preferred project report

Proposed 50 Berth Marina and Car Park

Crown Land above and below mean high water mark
off Brisbane Water Drive being Lot 519 DP 72902

December 2011

Ground Floor Plan

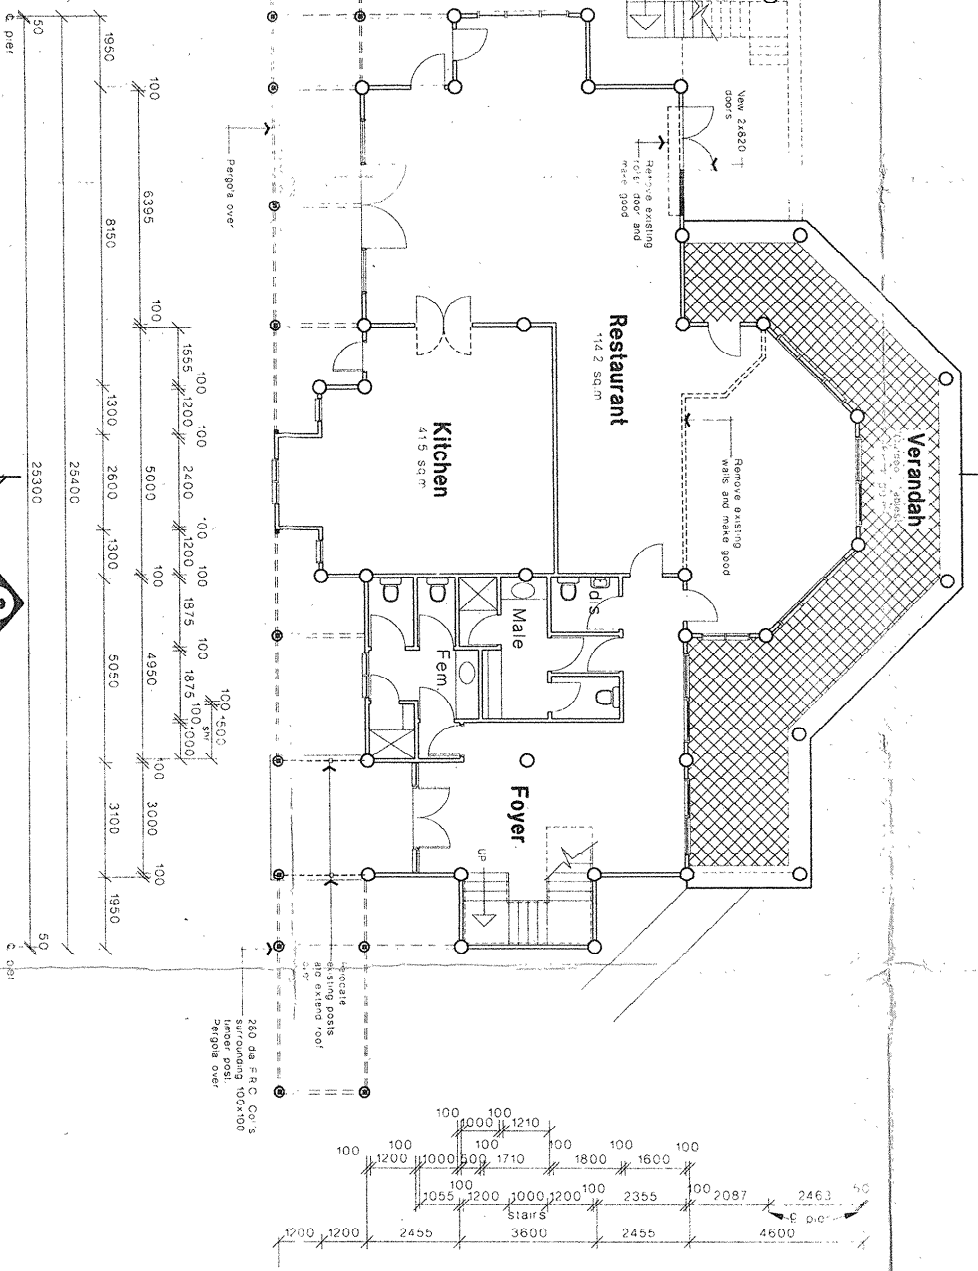
- *Has the use of any or all of the deck areas for restaurant purposes been taken into account in calculating the restaurant uses parking generation? If not, identify the potential impact of any additional space within the building on parking demand.*

Response: The verandah area ("deck areas") on the ground floor were included within the parking calculation as evidenced through the stamped and approved plans within Appendix 1b of the EA, and discussed at length within Section 6.2.7.3 – note the tabular break-down of approved parking required and proposed parking required. The deck area on the first floor and the first floor in general is not available or accessible to restaurant patrons and therefore not included within restaurant parking rates.
